SSD 9477 CATHERINE FIELD PRIMARY SCHOOL

Response to Submissions

PR145916-2
SSD 9477 Catherine Field
Primary School Response to
Submissions
3
1 May 2020

Figure 2: Indicative Pedestrian Crossing Locations

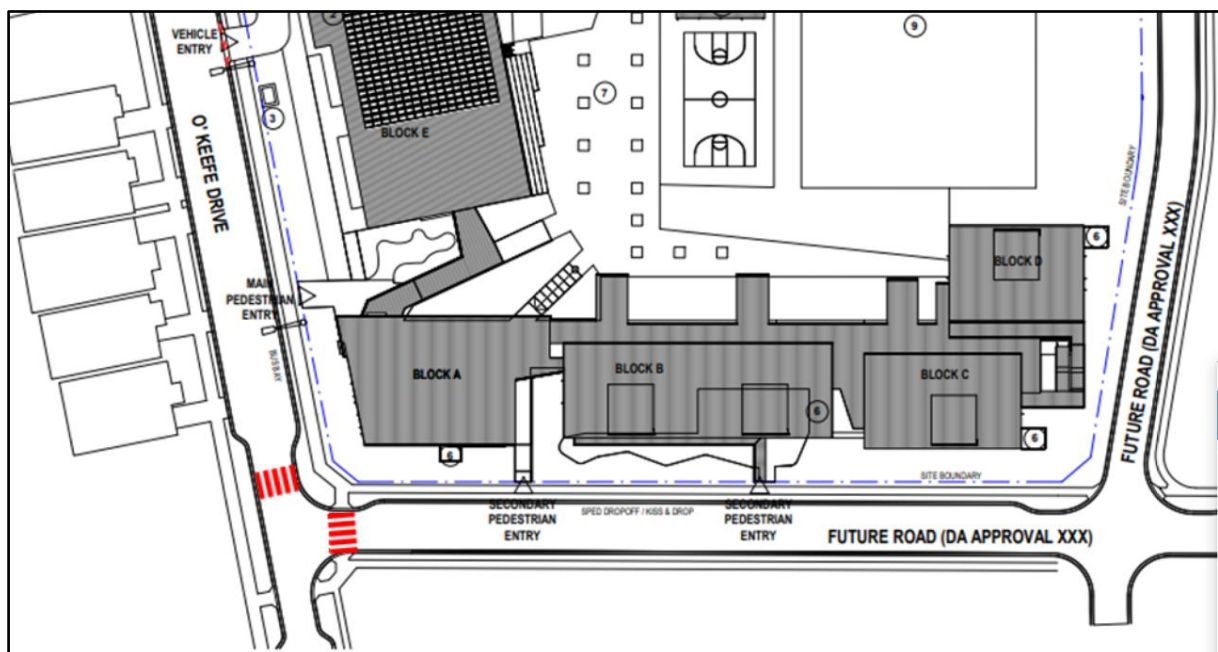
Traffic	1. Council requested signage and line marking places to be submitted and Local Traffic Committee concurrence to be sought. 2. It was noted the Traffic Impact Assessment states that the disabled parking will be accommodated within the staff car parking (68 spaces). Accessible spaces will impact the number of spaces provided as shared spaces (as per AS289). It was noted the shared spaces have not been considered as part of the car park layout. The number of accessible spaces provided shall be based on assessment of similar sites. It should be noted special needs stream would need to be provided at the proposed school. 3. Council requested a footpath along the 'future road' on the eastern frontage of the site. This is to consider the gate access no the frontage. 4. Council requested pedestrian crossings and for the locations to be identified. Crossing points should be provided on O'Keefe Drive and crossing points on the southern boundary road. 5. Council requested further information regarding the number of bus bays. The extent of the bus bays should be based no anticipated demand and consider	1. It is anticipated that the requirement to submit signage and line marking places will form a condition of consent. 2. All access, parking and servicing areas have been designed with reference to the appropriate Australian Standards. Specifically, AS 2890.1 (with regard to access driveways and parking modules) and AS 2890.2 (with regard to service vehicles) have been addressed. It is anticipated that a Condition of Consent in any future approval will require that the final design provides full compliance with the Australian Standards, which would provide for any minor design revisions that may arise through to construction commencing. The school does not have a Special Education requirement for the carpark. 3. The Eastern frontage does not currently have a student entry allocated. The gate shown on the drawings is emergency access for an ambulance to the playing field. 4. TfNSW has a reduced warrant for sites used predominately by children and by aged or impaired pedestrians. The criteria to assess whether a pedestrian crossing can be installed is not known for the school when it will be operational. While vehicle volumes can be forecast with relative accuracy and may exceed the requirement, the pedestrian volumes and desire lines may not. This is particularly relevant given that the number of possible directions and access desire lines – depending on specific enrolment locations within the catchment – is likely to significantly

Figure 3: School Peak Period Traffic Generation

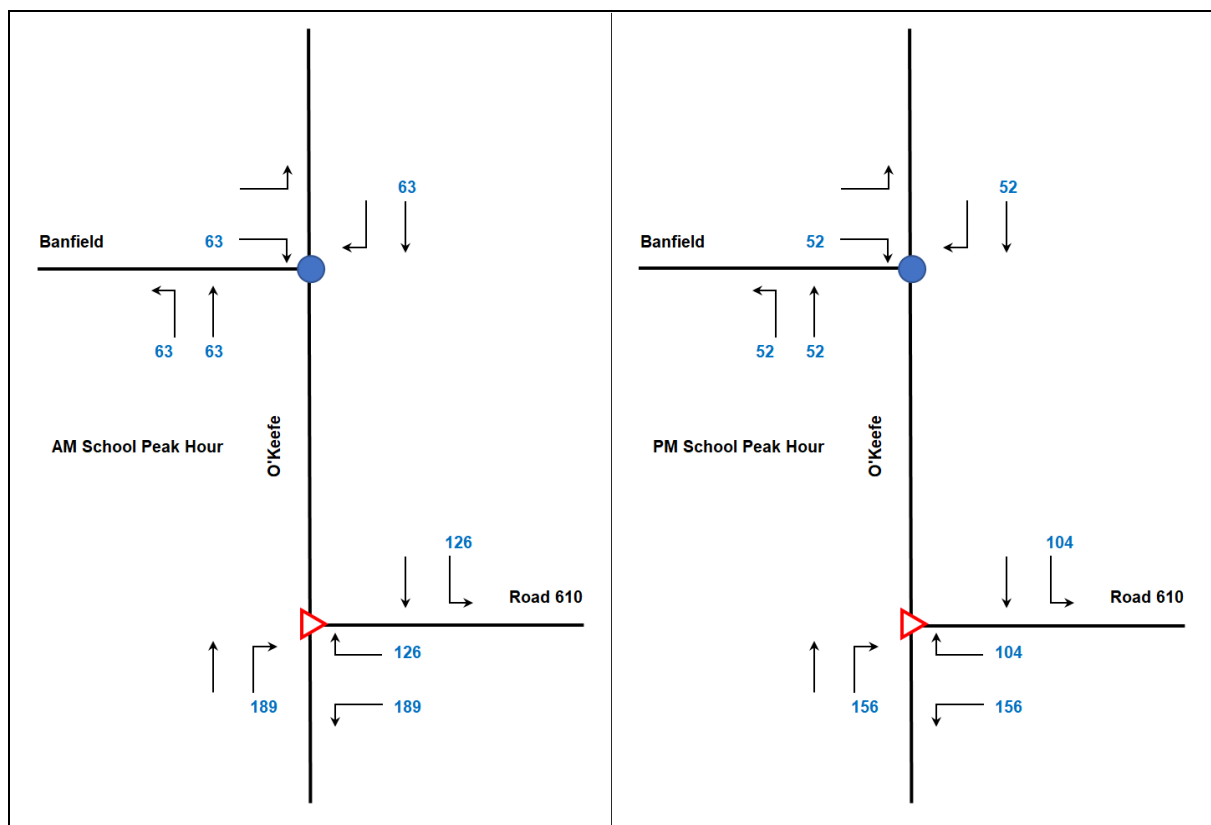
7. Council noted the distribution of peak hour traffic flow had not been discussed or justified.	6. Kerbside drop off and pick up will be accommodated at the appropriate location in the designated Drop Off Pick Up Zone (DOPUZ) to the south of the site on the Future Road, satisfying the requirement. Accordingly, the spaces will not be required in the car park which is a significant relative distance from the designated buildings. Appropriate signage and provision of a minimum of two car spaces shall be provided in the DOPUZ. 7. The school is centrally located within the Catherine Field (Part) Precinct (CFPP), and many students are expected to live within the CFPP. Consequently, student trips are expected to be distributed to the CFPP road network in accordance with residential densities (across the CFPP). Student vehicle trips are expected to be evenly divided in the School peak periods between inbound and outbound trips. Staff are expected to travel to/from the broader sub-region, with only a minority of trips generated within the CFPP. During the AM school peak period, all staff trips are expected to be arrival trips, while during the PM school peak period all staff trips are expected
